Fire Marshal Division

RE: Sheetz
NC 24 Hwy / Sawyer Rd.
Cameron, NC 28326

Re: Application Number – BCOM2103-0004

# SHEETZ FIRE SUPPRESSION PLANS

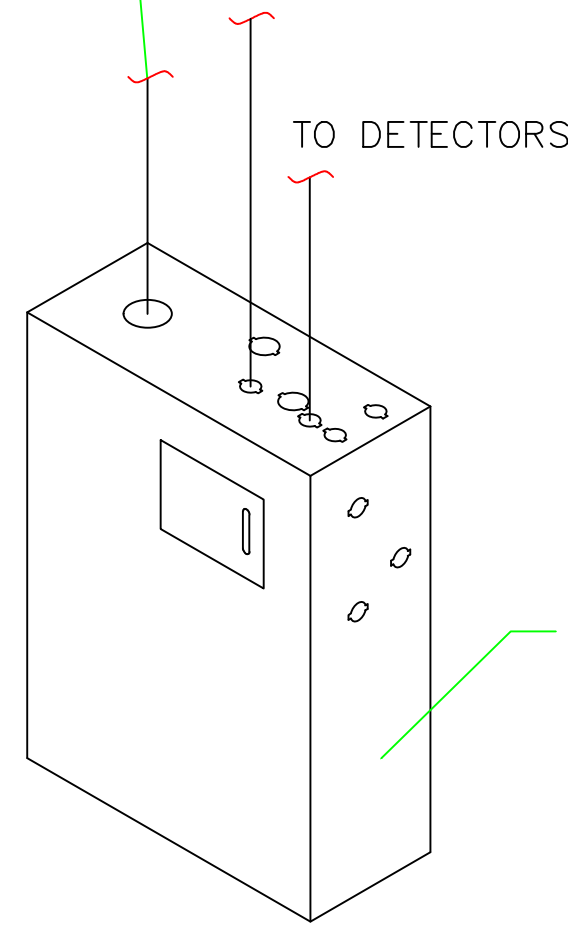
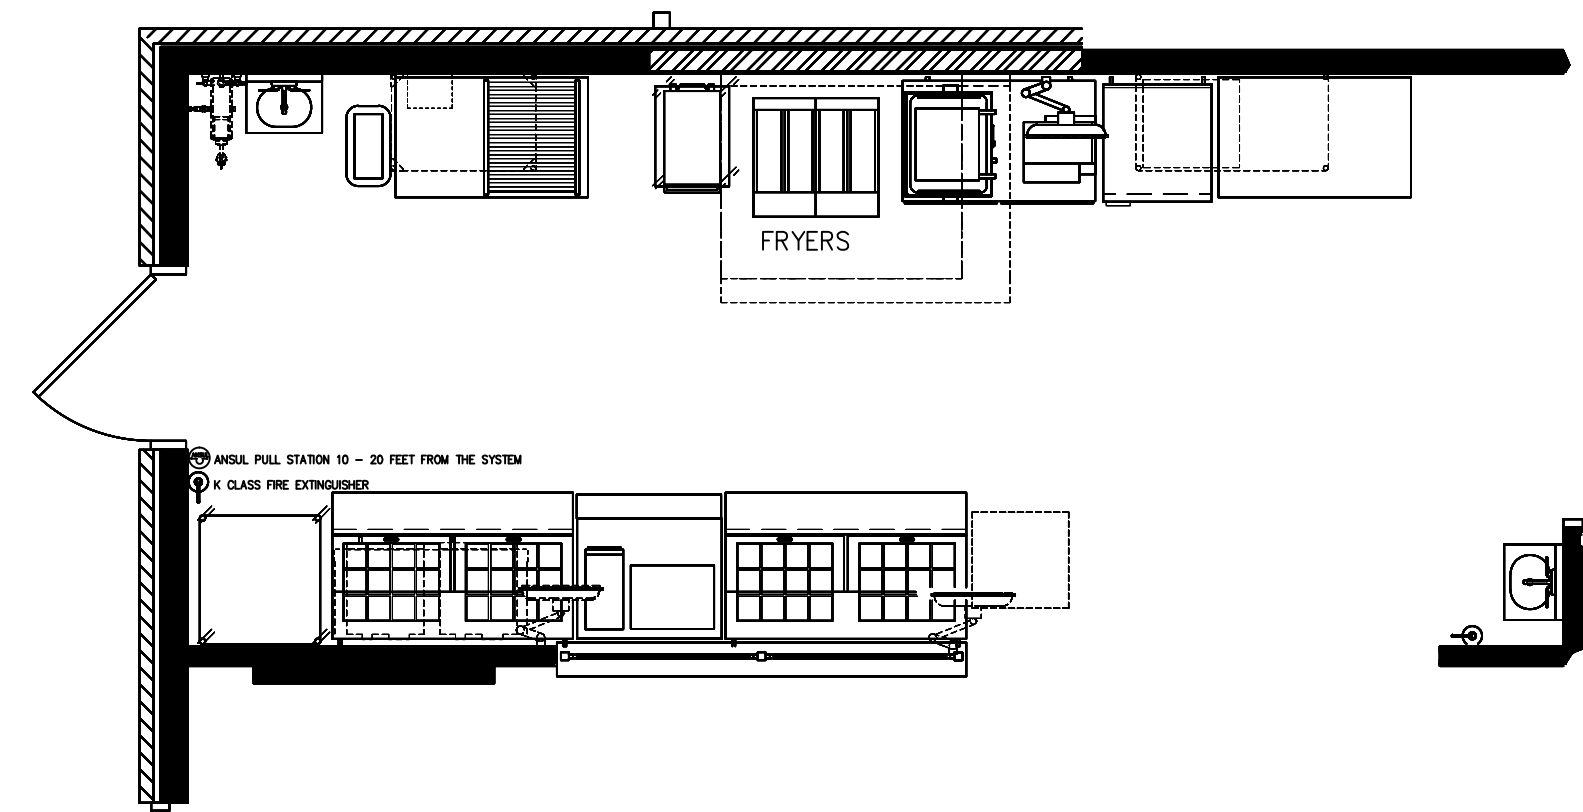
- **Commercial hood and duct systems.**
 - Each required commercial kitchen exhaust hood and duct system required by Section 609 to have a Type I hood shall be protected with an *approved* automatic fire-extinguishing system installed in accordance with this code.

- An additional permit is required for kitchen hood suppression system.
 - Provide shop drawings and cut sheets.
- **Commercial cooking systems.**
 - The automatic fire-extinguishing system for commercial cooking systems shall be of a type recognized for protection of commercial cooking equipment and exhaust systems of the type and arrangement protected. Pre-engineered automatic dry- and wet-chemical extinguishing systems shall be tested in accordance with UL 300 and *listed* and *labeled* for the intended application. Other types of automatic fire-extinguishing systems shall be *listed* and *labeled* for specific use as protection for commercial cooking operations. The system shall be installed in accordance with this code, its listing and the manufacturer's installation instructions. Automatic fire-extinguishing systems of the following types shall be installed in accordance with the referenced standard indicated, as follows:

- **Portable fire extinguishers for commercial cooking equipment.**
 - Portable fire extinguishers shall be provided within a 30-foot (9144 mm) travel distance of commercial-type cooking equipment. Cooking equipment involving solid fuels or vegetable or animal oils and fats shall be protected by a Class K rated portable extinguisher in accordance with Sections 904.11.5.1 or 904.11.5.2, as applicable.
